# *City of Albuquerque*

**RE: McDONALD'S / CHEVRON @ CENTRAL & WYOMING (K19-D32A).  
ENGINEER'S CERTIFICATION FOR CERTIFICATE OF OCCUPANCY  
APPROVAL. ENGINEER'S STAMP DATED FEBRUARY 9, 2000.**

**RE: McDONALD'S / CHEVRON @ CENTRAL & WYOMING (K19-D32A). DRAINAGE REPORT AND GRADING PLAN FOR PRELIMINARY PLAT, BUILDING PERMIT, AND GRADING/PAVING PERMIT APPROVALS. ENGINEER'S STAMP DATED JUNE 15, 1999.**

Re: Site Plan submittal for building permit approval for McDonald's/Chevron, Central Avenue N.E.  
(at Wyoming Street), Mesa Verde Addition, Tract C/Tract A, Block 8, Lots 1-7 and 12-15,  
(Zone Map K-19-Z), Architect's Stamp - None.

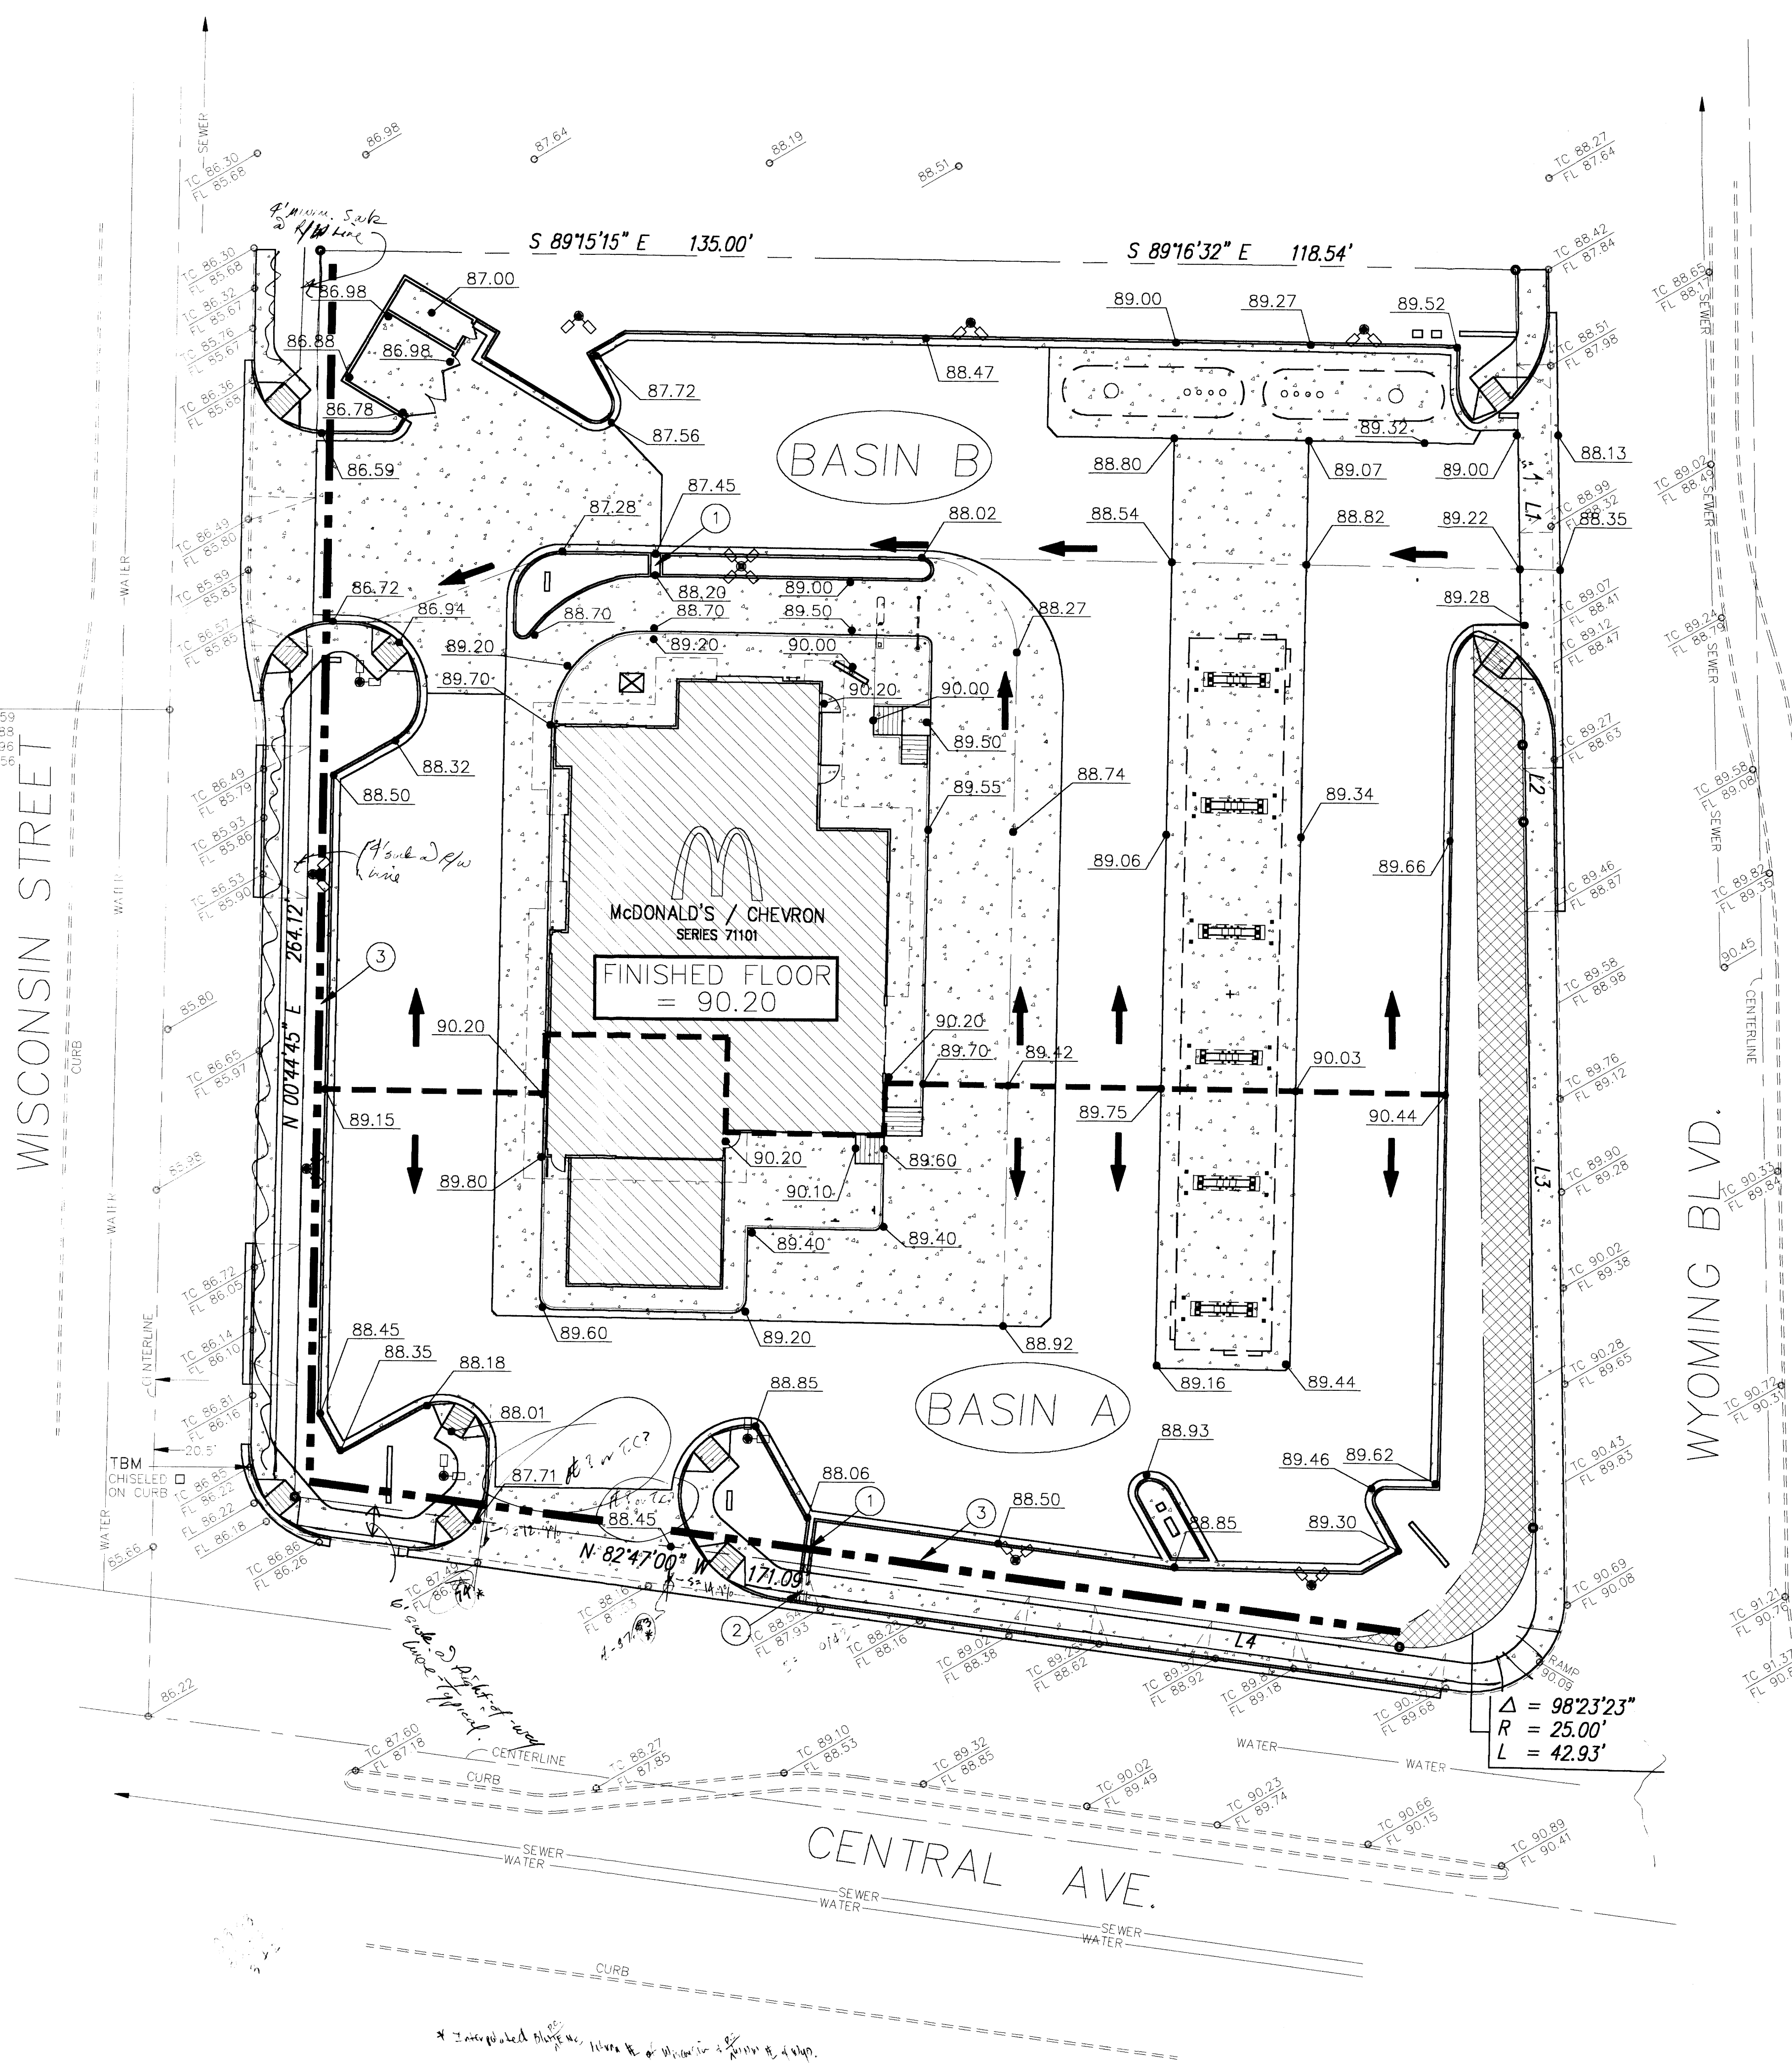
- j. Linework onDrainagePlan andLandscapePlan must matchSitePlan exactly. Per DPM,23.6B.11a, drive apron grade max. is 6% for curb return drives on Central and Wyoming.

- Sidewalk raised 6" above parking surface, needed at the front of parked vehicles along the front of building. Need to see on Drainage Plan that there is a difference between the top of sidewalk and the top of asphalt surface.
